Longfield Solar Farm

Chelmsford City Council

Unique reference: LOSF - 002

ExQ1 - Responses to Written Questions

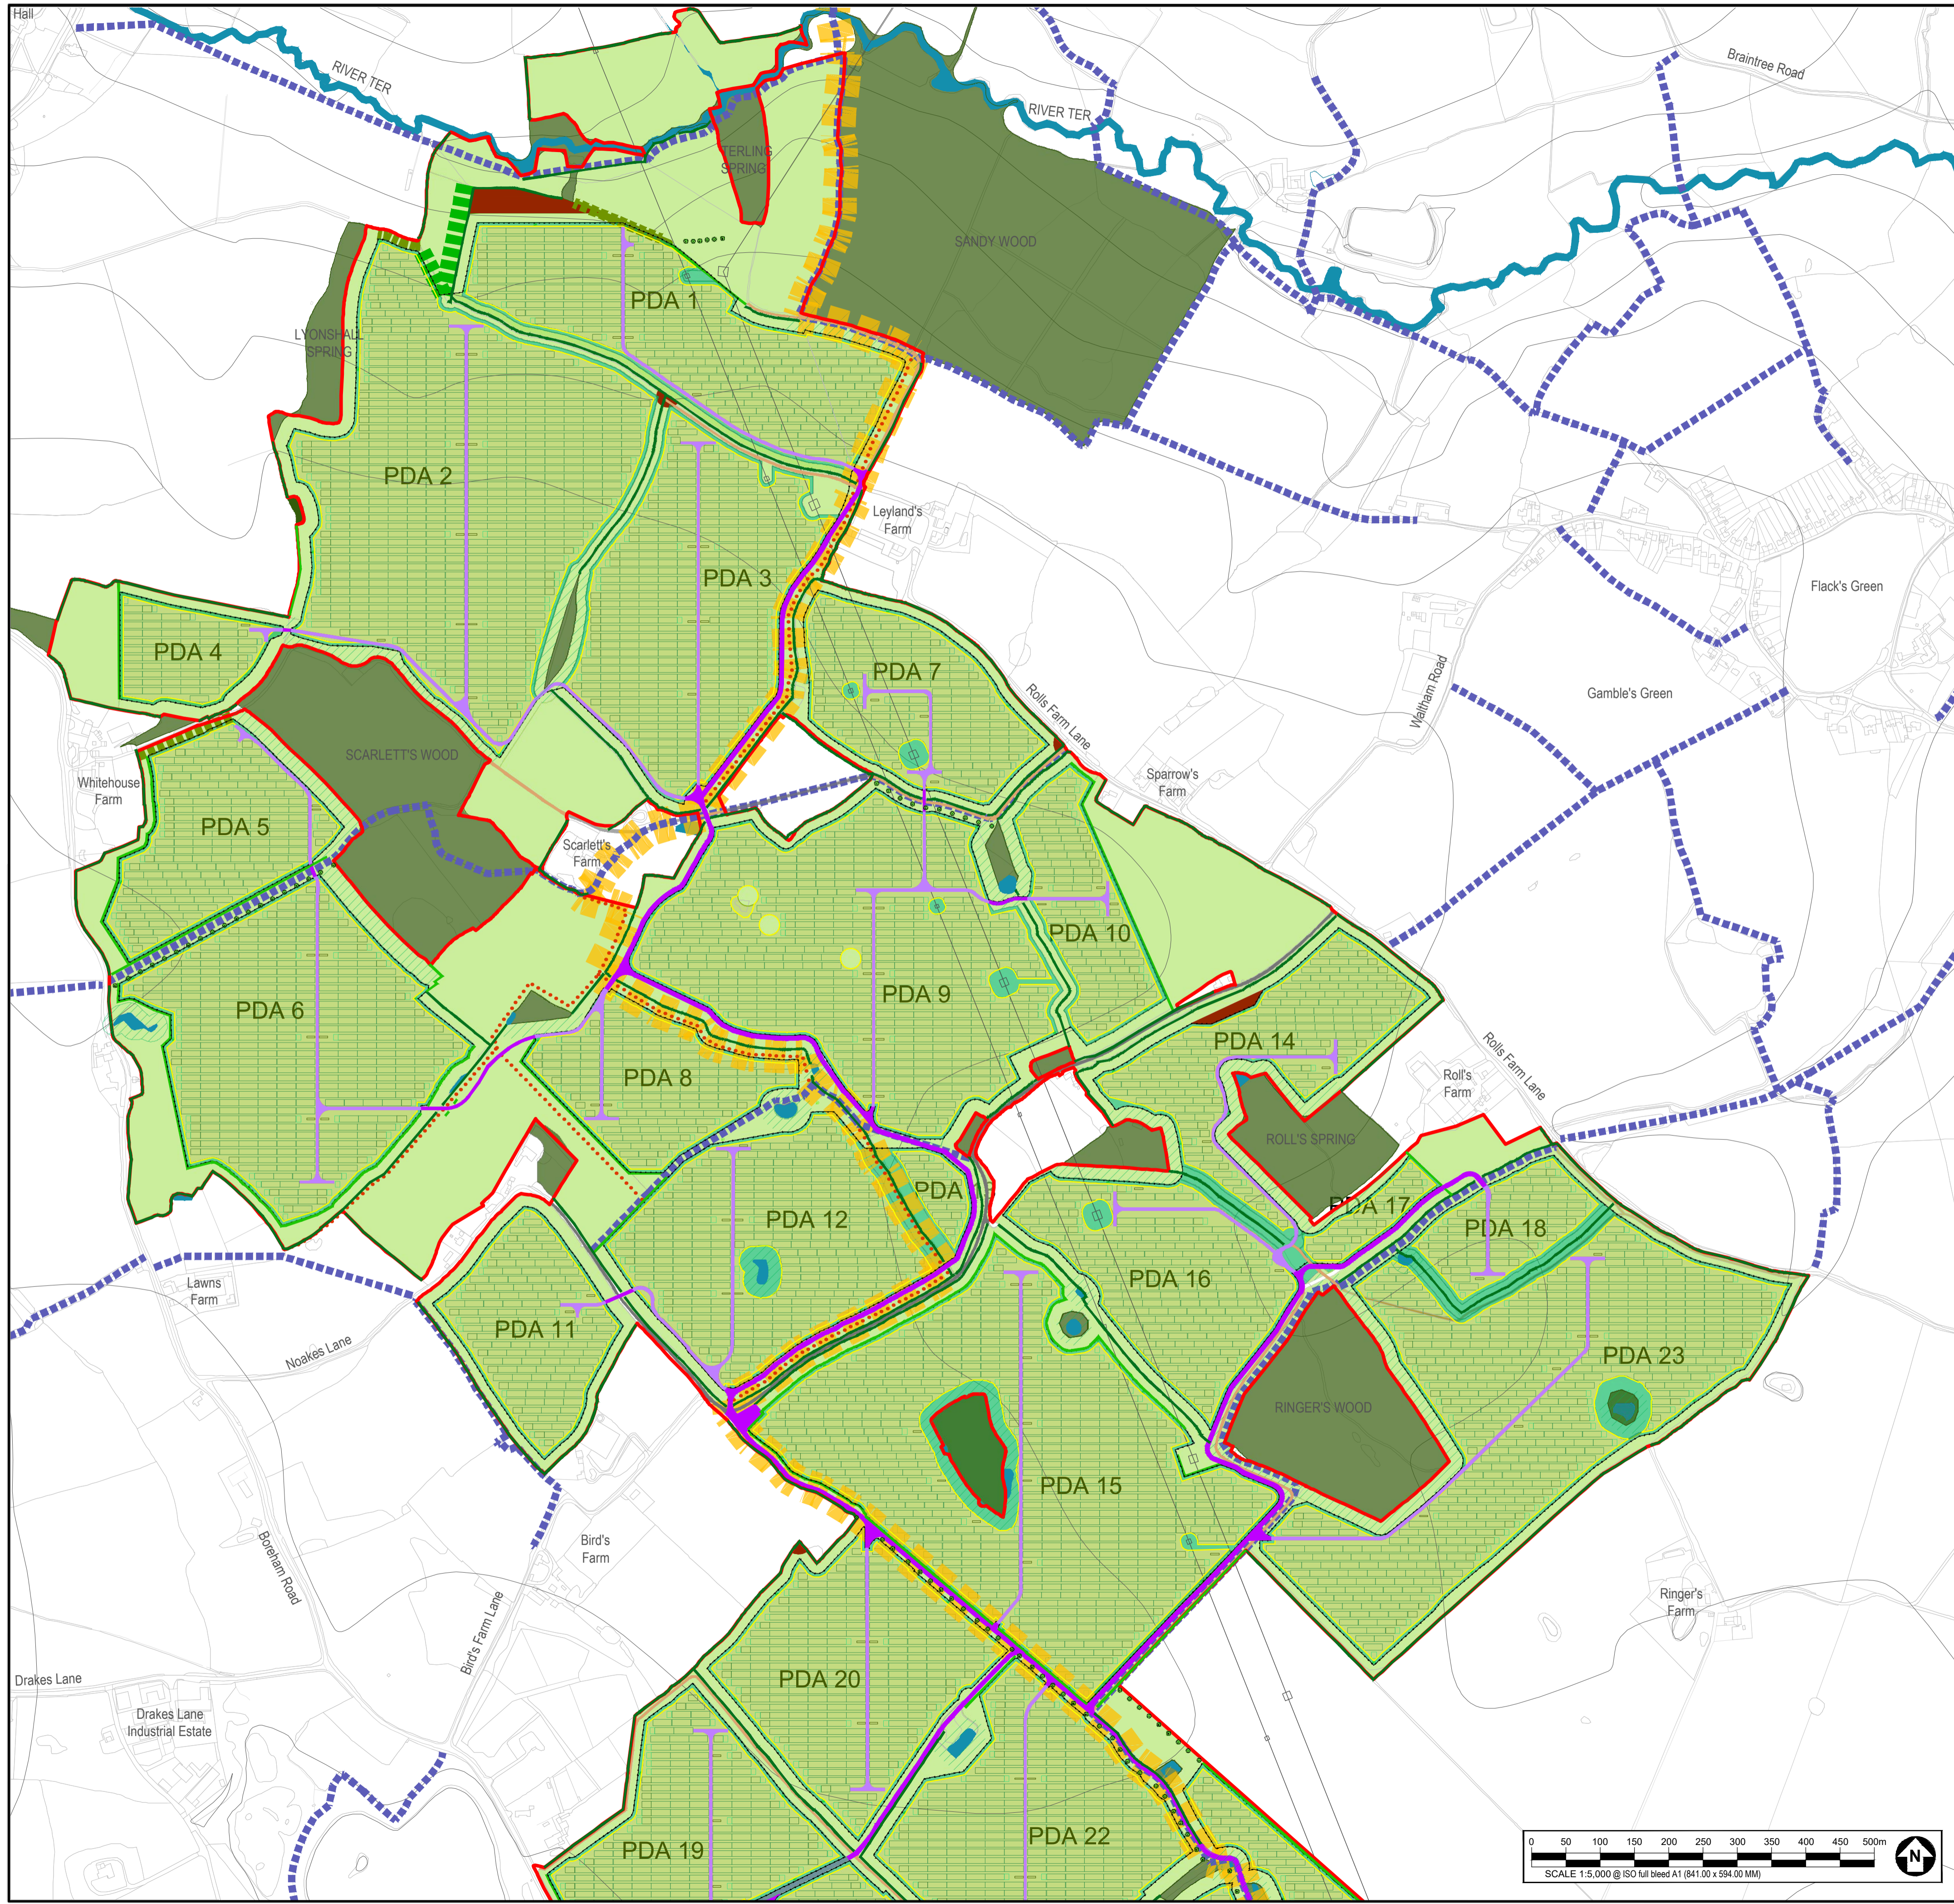
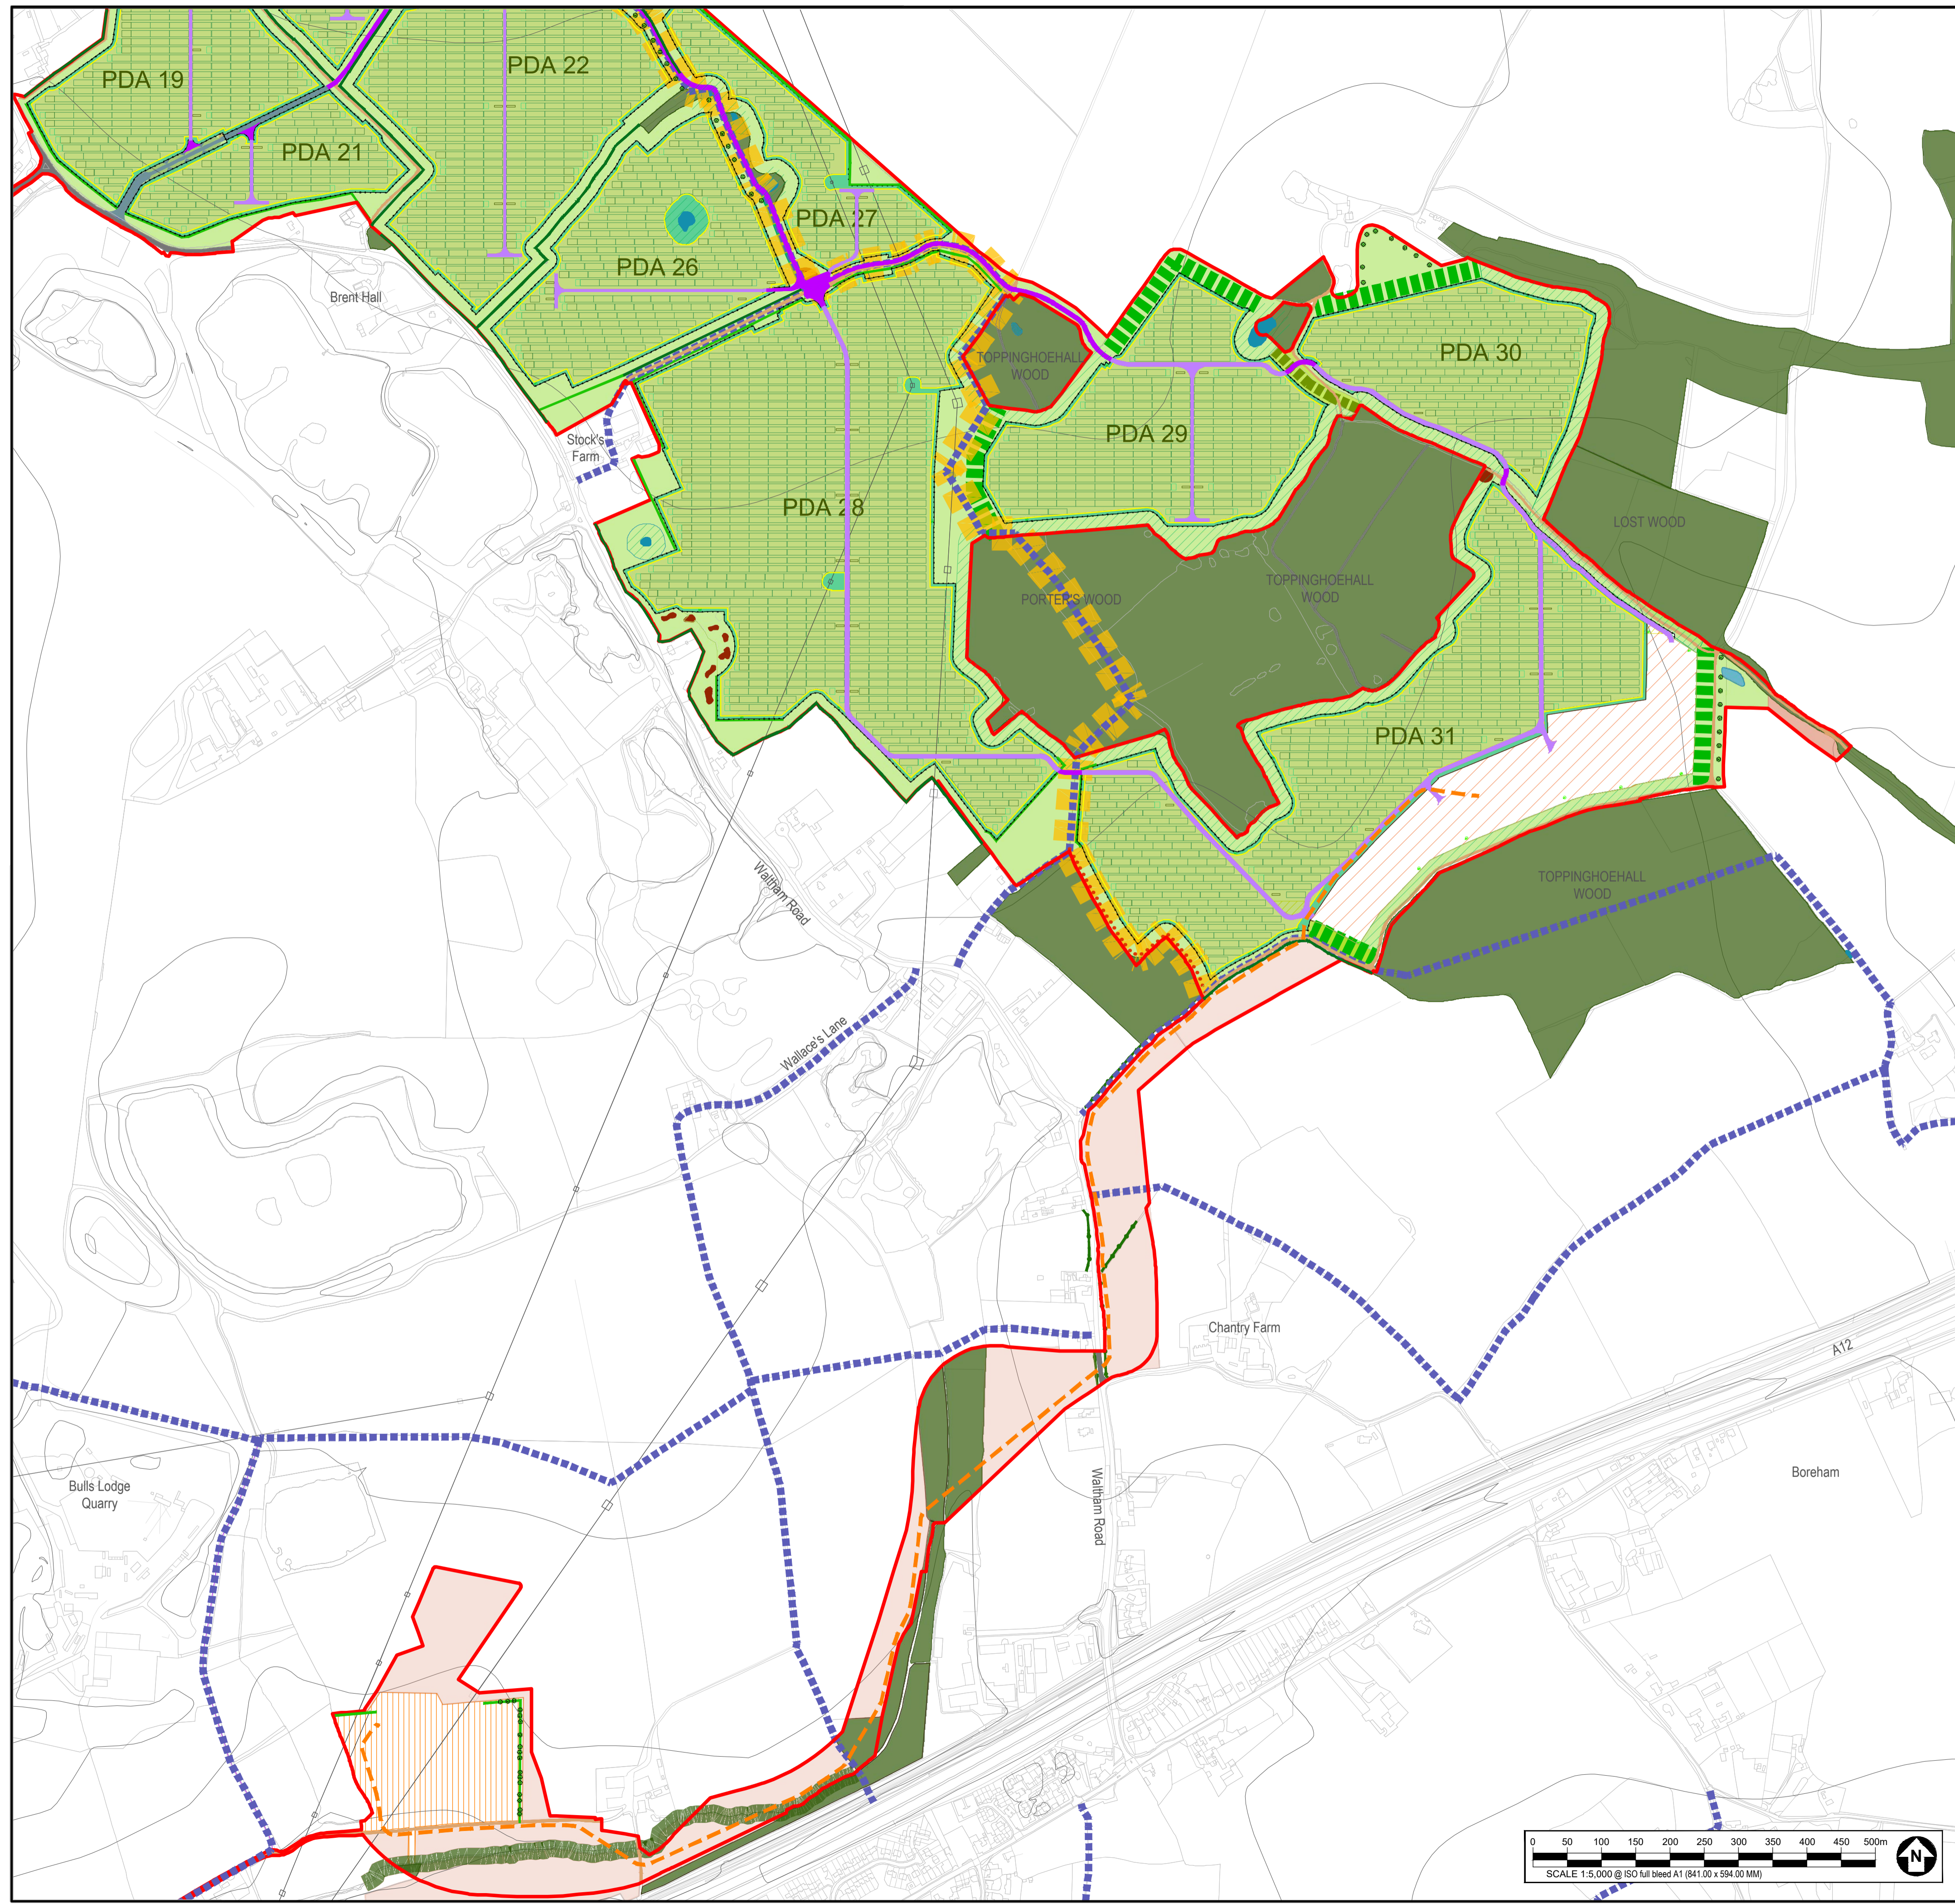
1.8.3	Host Authorities	Could the relevant Host Authorities confirm whether they are in agreement with the proposed landscaping mitigation measures and (as relevant) monitoring proposals, as set out in the Outline Landscape Masterplan [APP-179], the oCEMP [APP-214], oOEMP [APP-215] and the oLEMP[APP-217]?	<p>CCC confirm it is content in principle subject further to further discussion on the following three items:</p> <ol style="list-style-type: none"> 1. Approach to vegetation removal / management on Noakes Farm Lane (protected lane) 2. Screening of view from Viewpoint 45 (Essex Way north of River Ter) 3. Advance planting of PDA 1 scrub area
